## WEST SUSSEX COUNTY COUNCIL CONSULTATION

| <b>LOCATION:</b>                | 25 Pevensey Road, Bognor Regis, PO21 5NS                                                                                |
| <b>SUBJECT:</b>                 | BR/229/21/HH<br>First floor side extension, mansard roof extension with 2 x side dormers and installation of crossover. |

FRONTAGE PARKING AND CROSSOVER

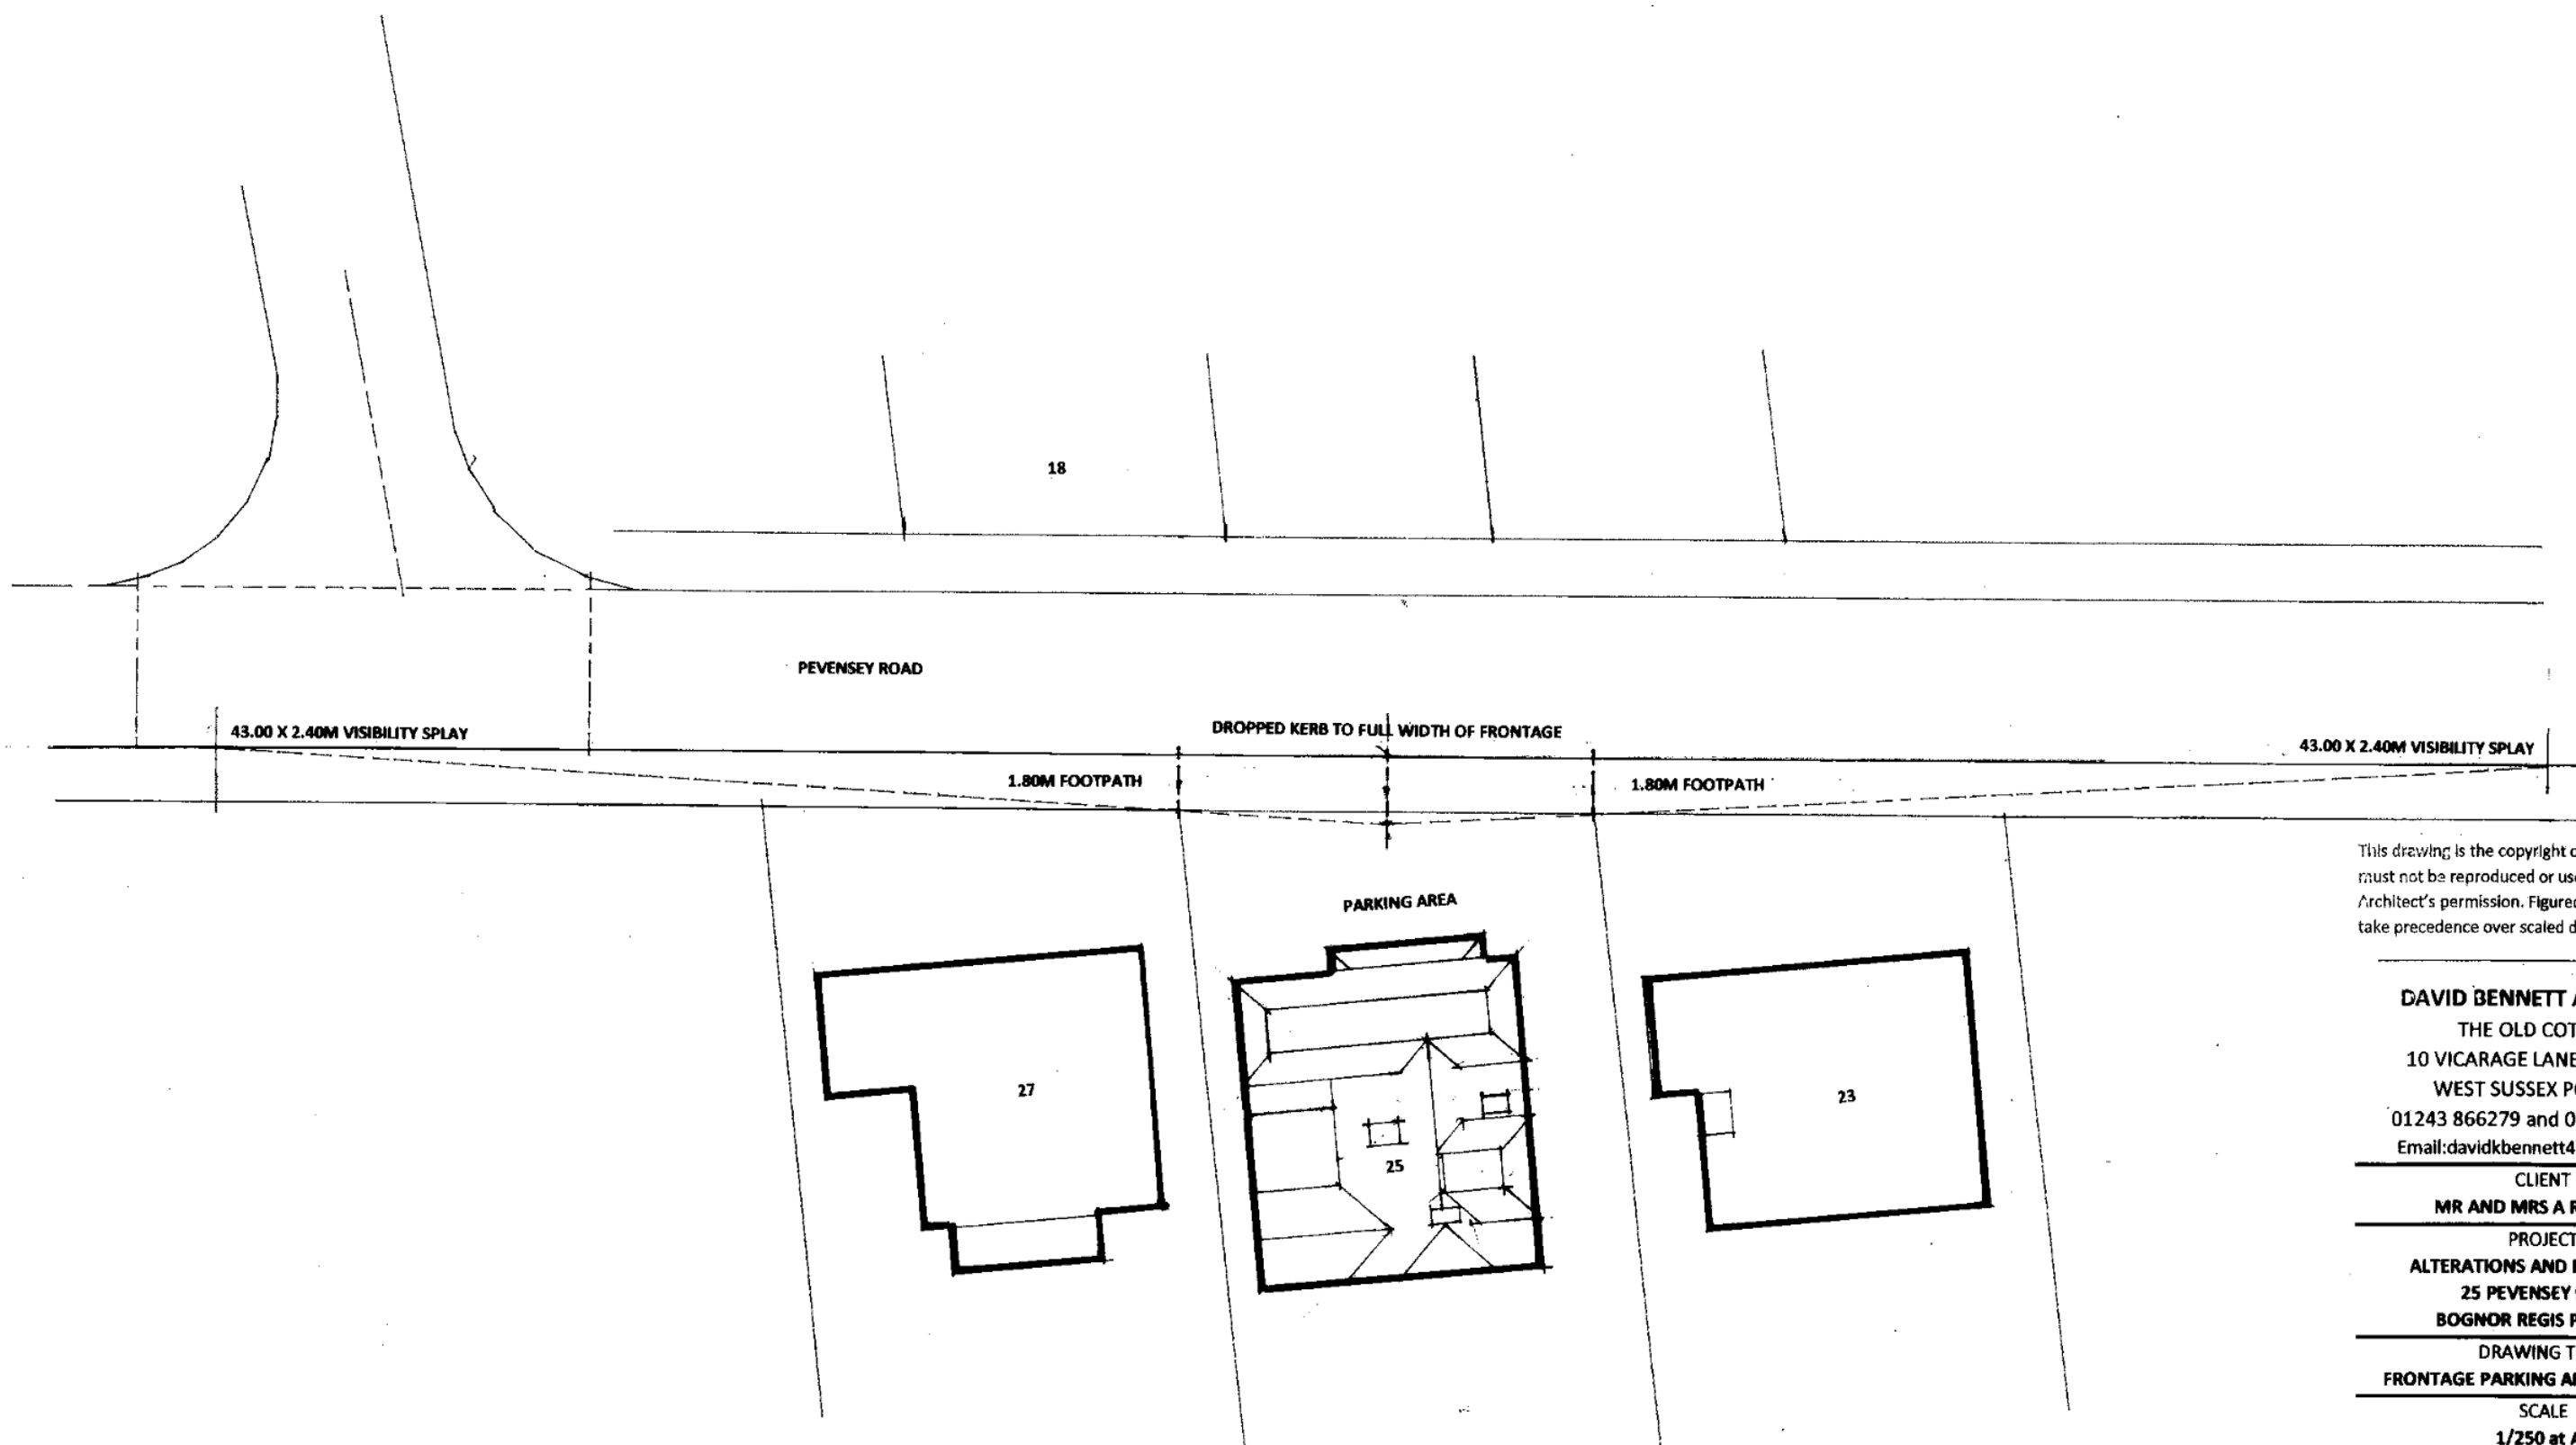
Regarding access, the applicant proposes to drop the entire kerb fronting the property, providing an approximate 15m wide VCO. The applicant has demonstrated suitable visibility splays for the proposed point of access on to Pevensey Road. The proposed access works will be subject to a licence obtained through the local area office and constructed to a specification agreed with the local area engineer.

The applicant should be made aware that under current area office guidance, the maximum permitted width for a VCO is 6.4m. As the proposals include a widening to 15m, further dialogue with the area office will be required, to justify the proposed width.

In addition, parts of the site frontage are below the minimum required depth of 4.8m. The plans demonstrate a car parking space positioned parallel to the edge of the highway. Typically, car parking spaces should be positioned perpendicular to the highway and as such, further dialogue with the area office may be required regarding this also.

However as mentioned above, some elements of the proposed VCO are contrary to current area office guidance and as such, may not be granted a licence. The applicant is advised to contact the local area office to gauge the suitability of the access proposals.
